Re: Sketch Plat Resubmission for Proposed Minor Subdivision Plat for the N'ly Port. Tract 43, Alvarado Gardens; Lot 6, Boulevard Gardens Subdivision; Tract 16A1, MRGCD Map No. 34

The sketch plat review was initially held June 5, 2024 under PS-2025-00092 and comments from that meeting are addressed below:

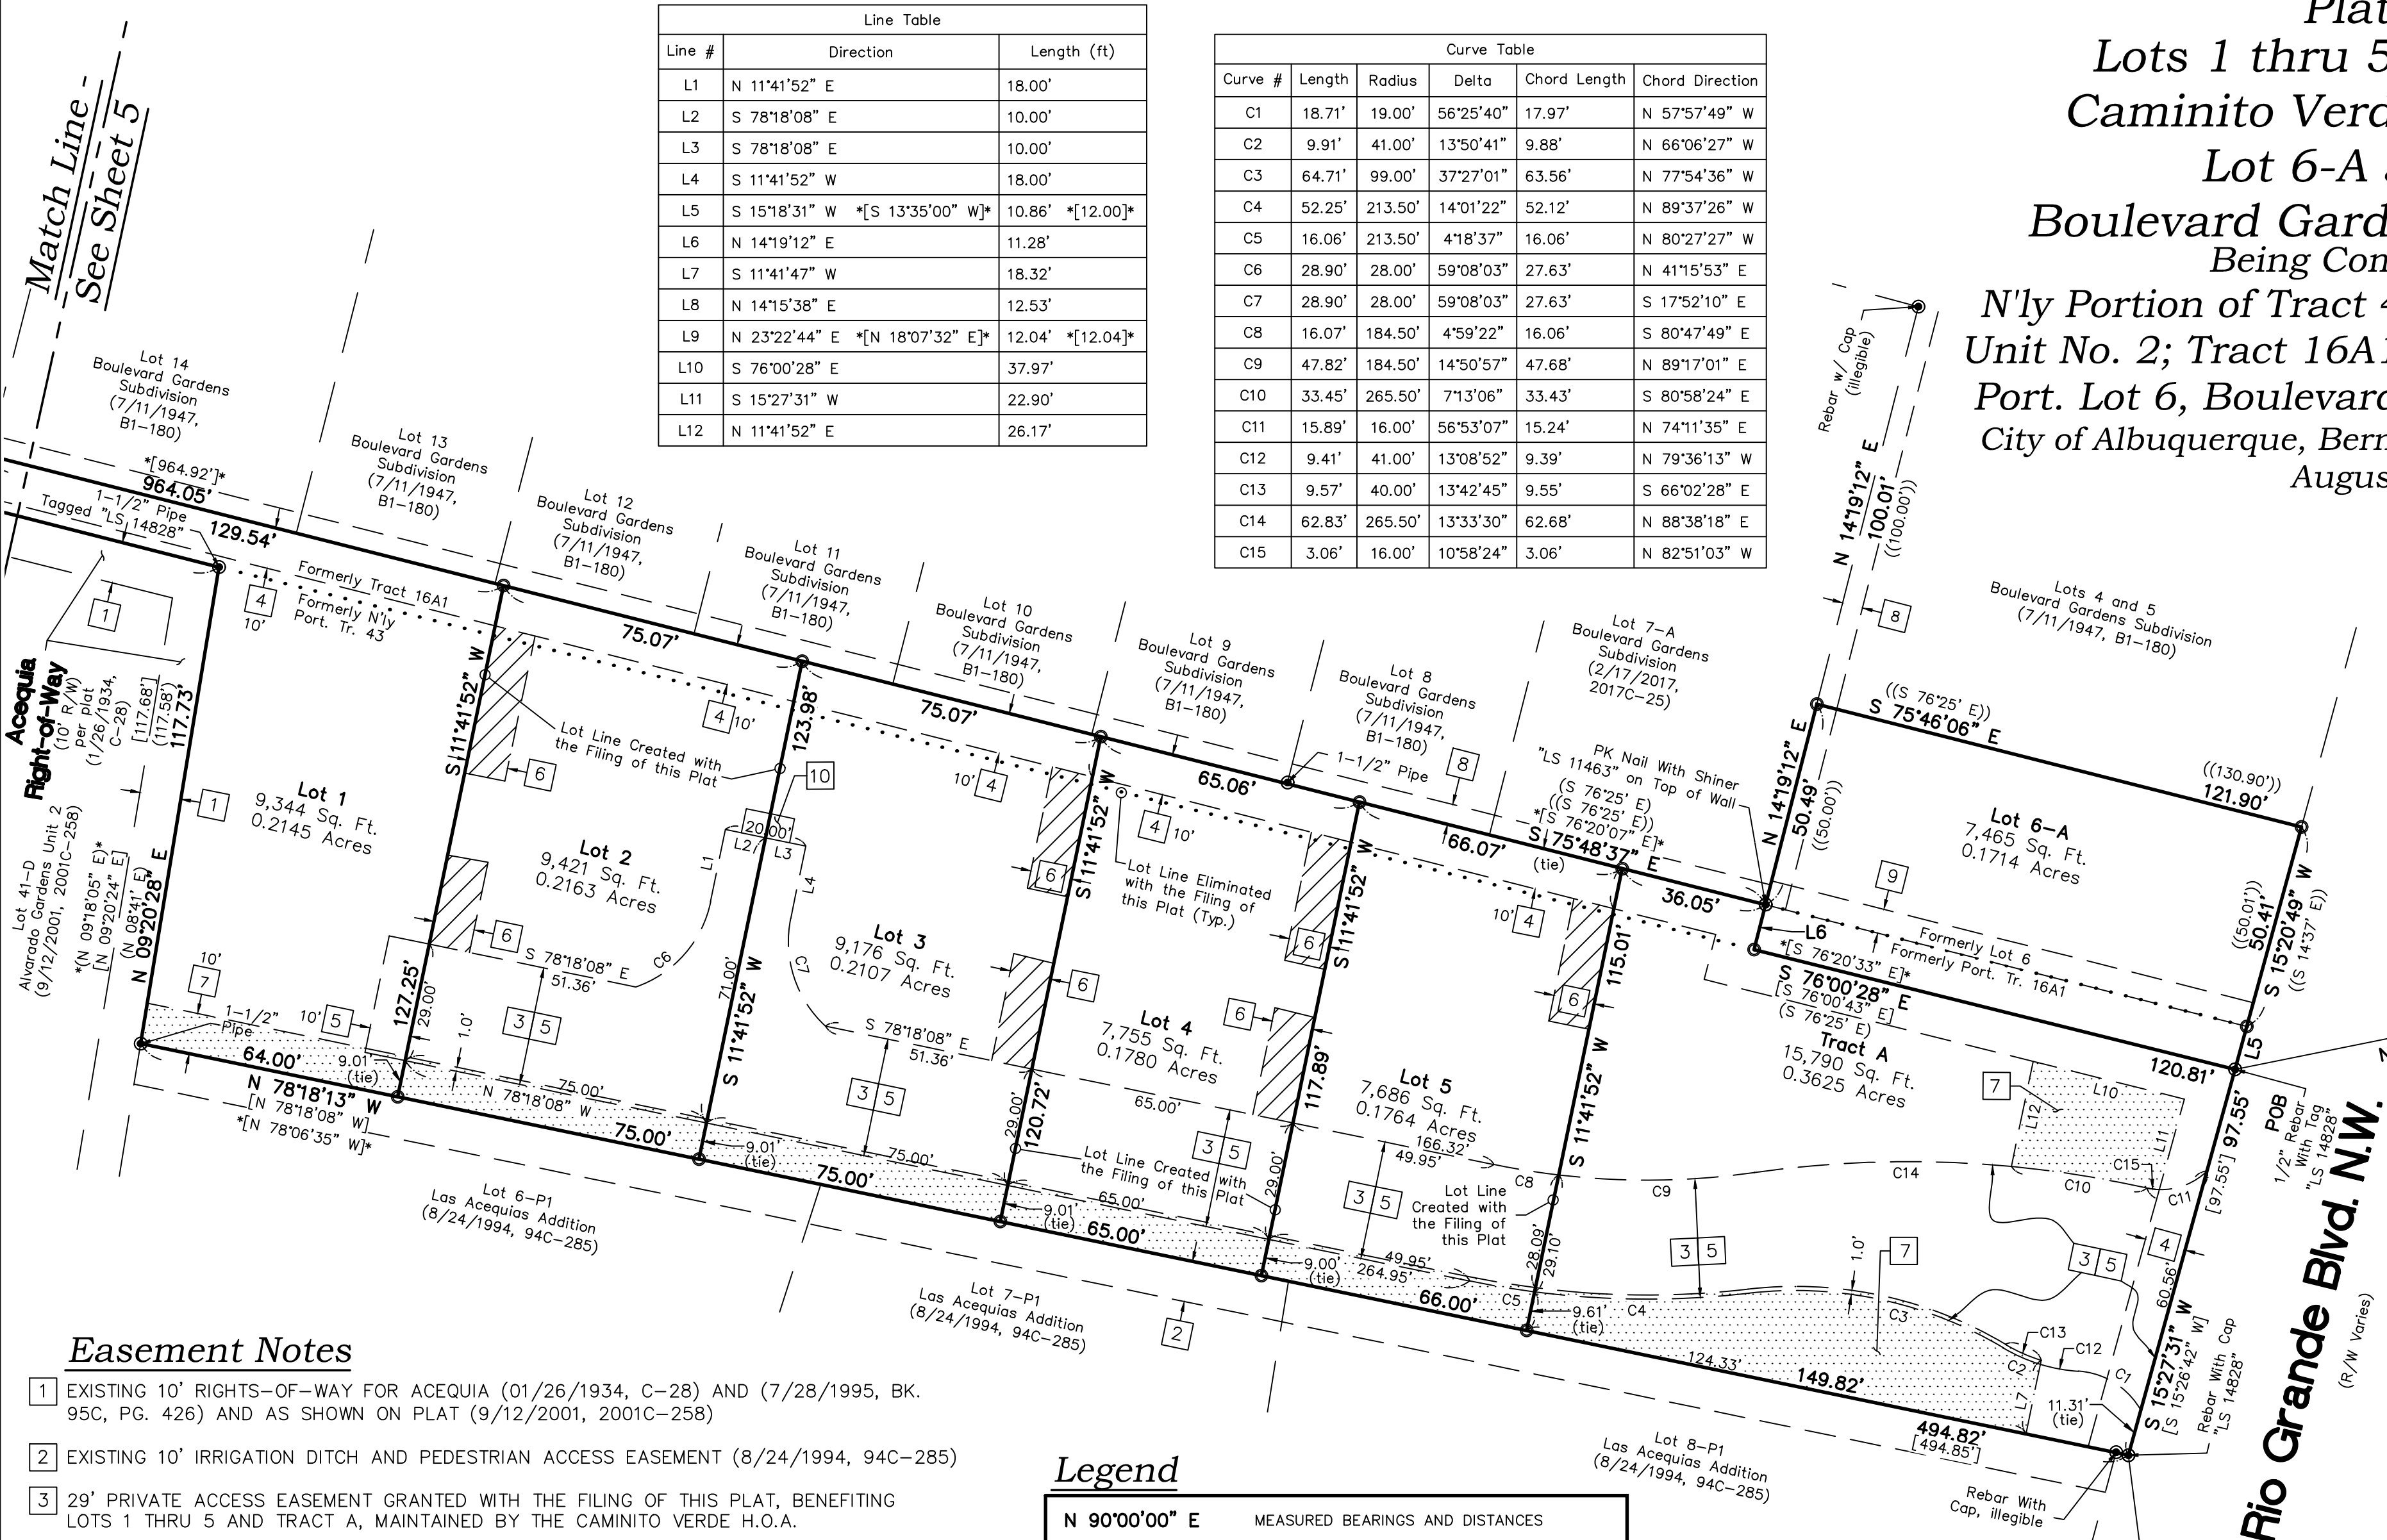
1. Please place a Request for Availability online at the following link:
http://www.abcwua.org/Availability_Statements.aspx. Requests shall include fire marshal requirements. An executed statement must be obtained prior to approval.
2. Infrastructure improvements are anticipated and will need to be included on an infrastructure list.
3. Please provide a utility plan showing all dimensions and easements.
4. Each lot shall have separate water and separate sanitary sewer services.

2. The width of the Private Way you have shown meets requirements of the DPM, but per the DPM you will need to provide a 5' sidewalk along one side of the way.

Noted, water and sewer lines are to be provided within a public water and sanitary sewer easement [5] which is typically 29 feet wide to correspond to the private access drive for the 5 lots created. See site sketch attached.

Noted, our client intends to provide a 5ft stabilized trail with direct access to each residence's patio within easement [4] to better accommodate pedestrian traffic and future property owners.
